Demolition of existing garage, utility & w.c.; construction of new single storey side and rear extension to provide enlarged kitchen, utility room, shower room and study.
47 North Lane East Preston

I regret that I am unable to accept your documents as a formal application until the following matters have been resolved :-

SITE BLOCK PLAN (1:500)

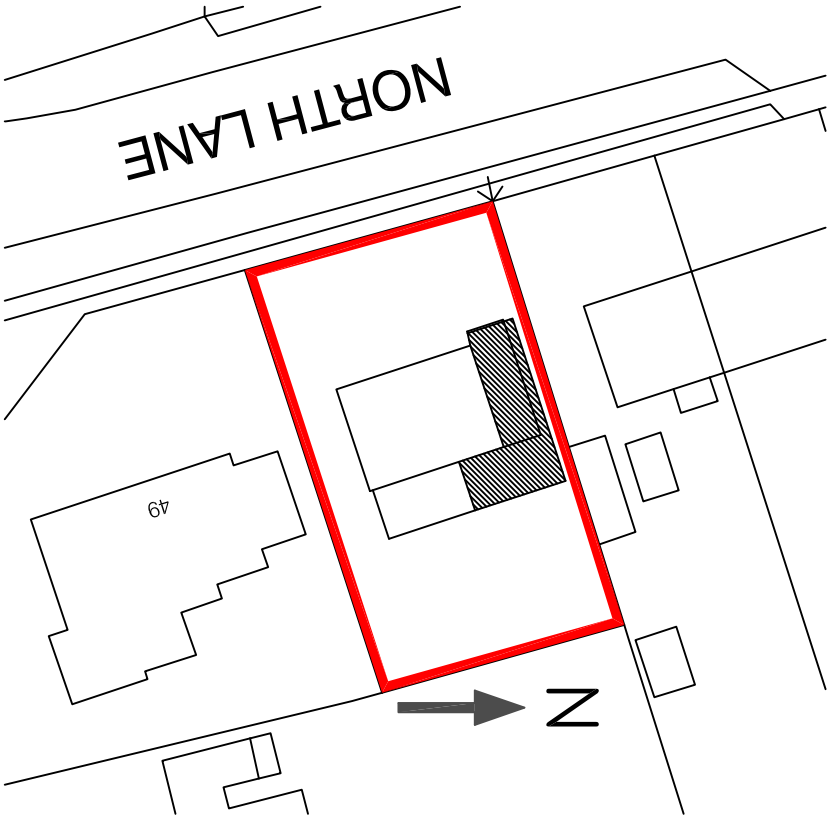
I require 1 electronic or 3 paper copies of a block/site plan in accordance with the guidance notes available on our website detailed below (click on National List). Please provide one named road.

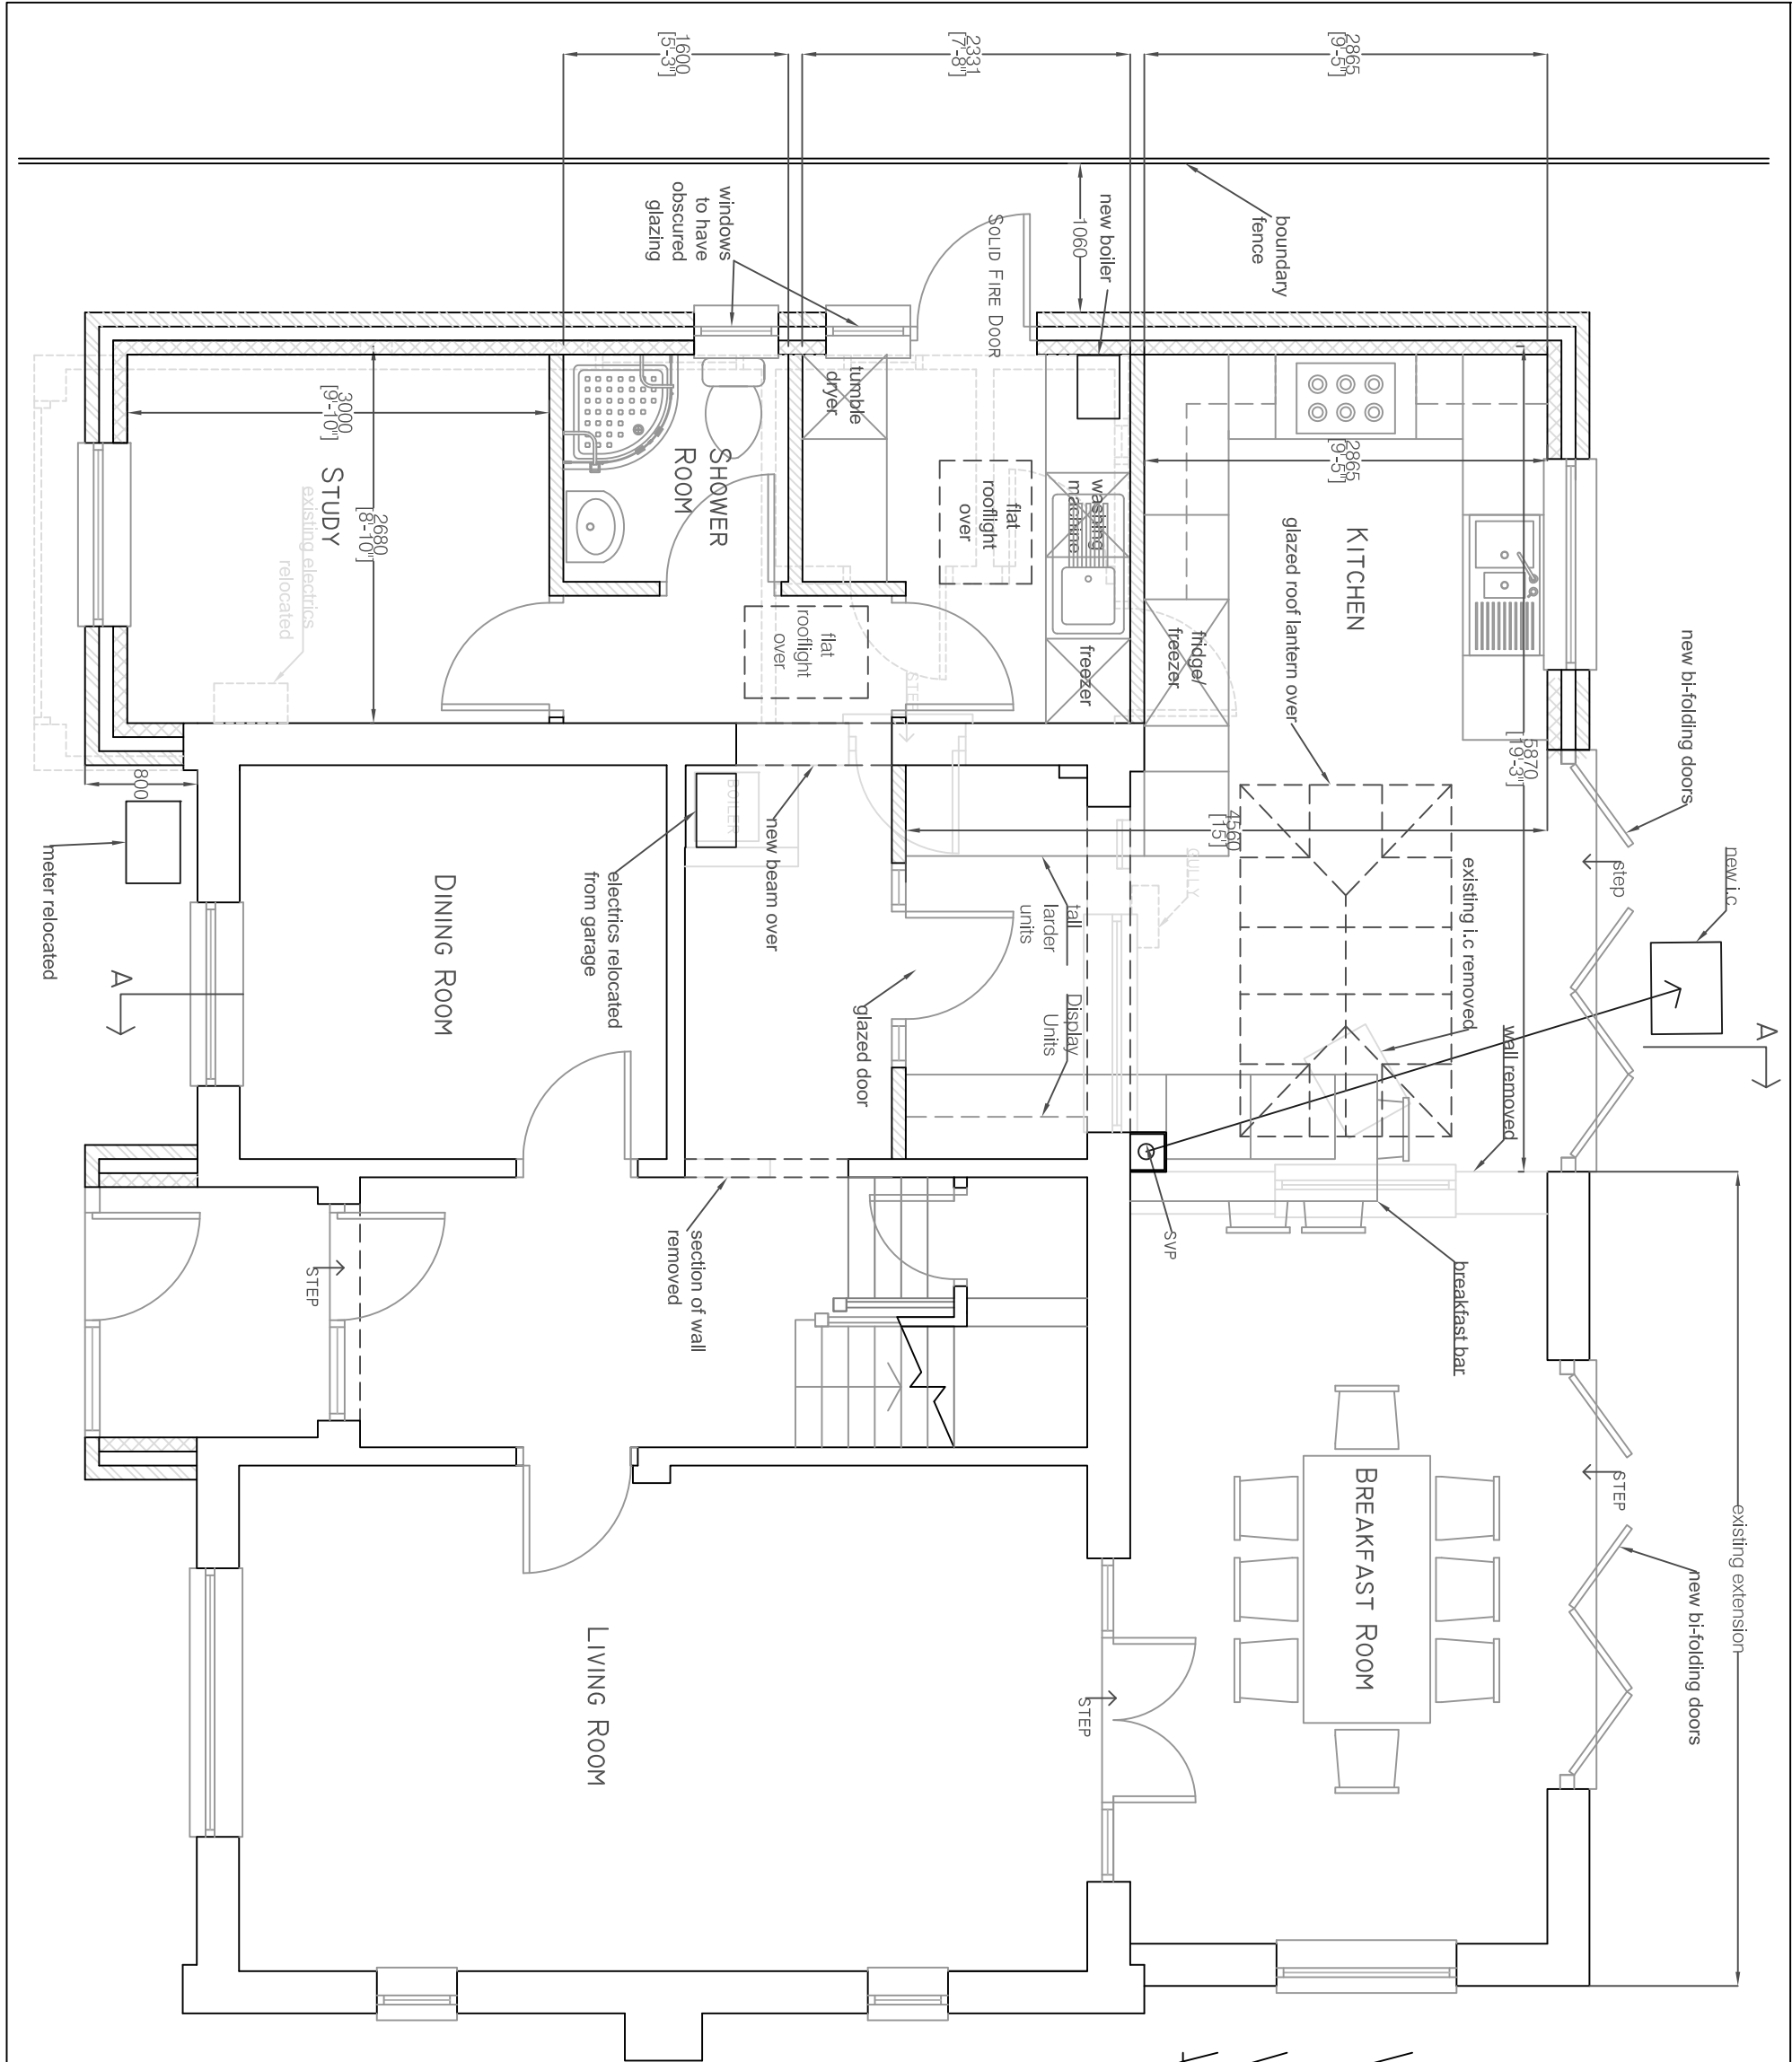
The proposed North floor plan and proposed North elevation at ground floor level do not accord (fire door). Please amend accordingly.

SITE LOCATION PLAN (1:1250)

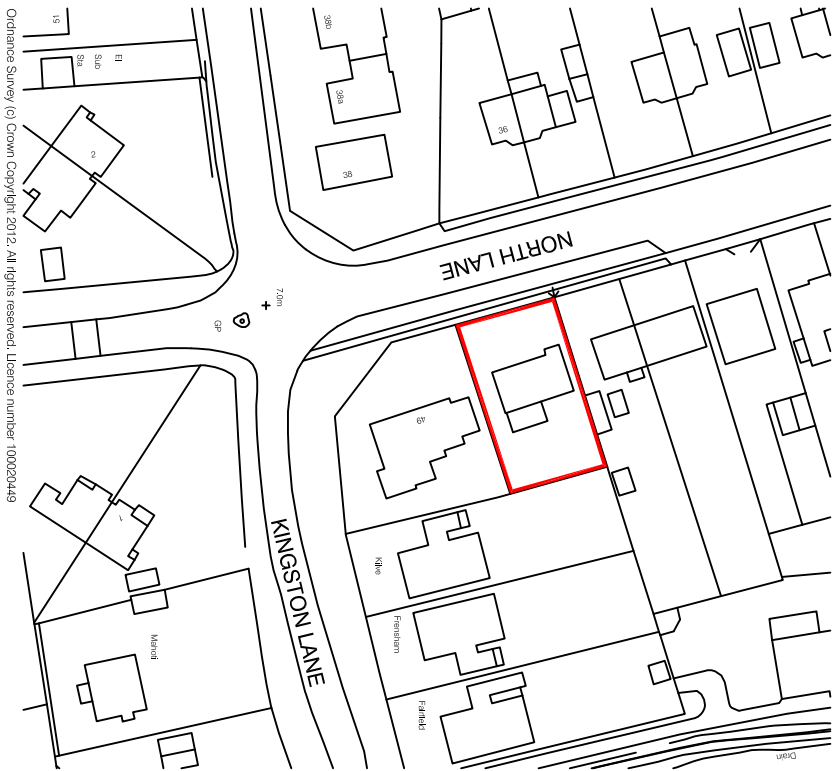
I require 1 electronic or 3 paper copies of a location plan in accordance with the guidance notes available on our website detailed below (click on National List). Please provide two named roads and edge the site in red.
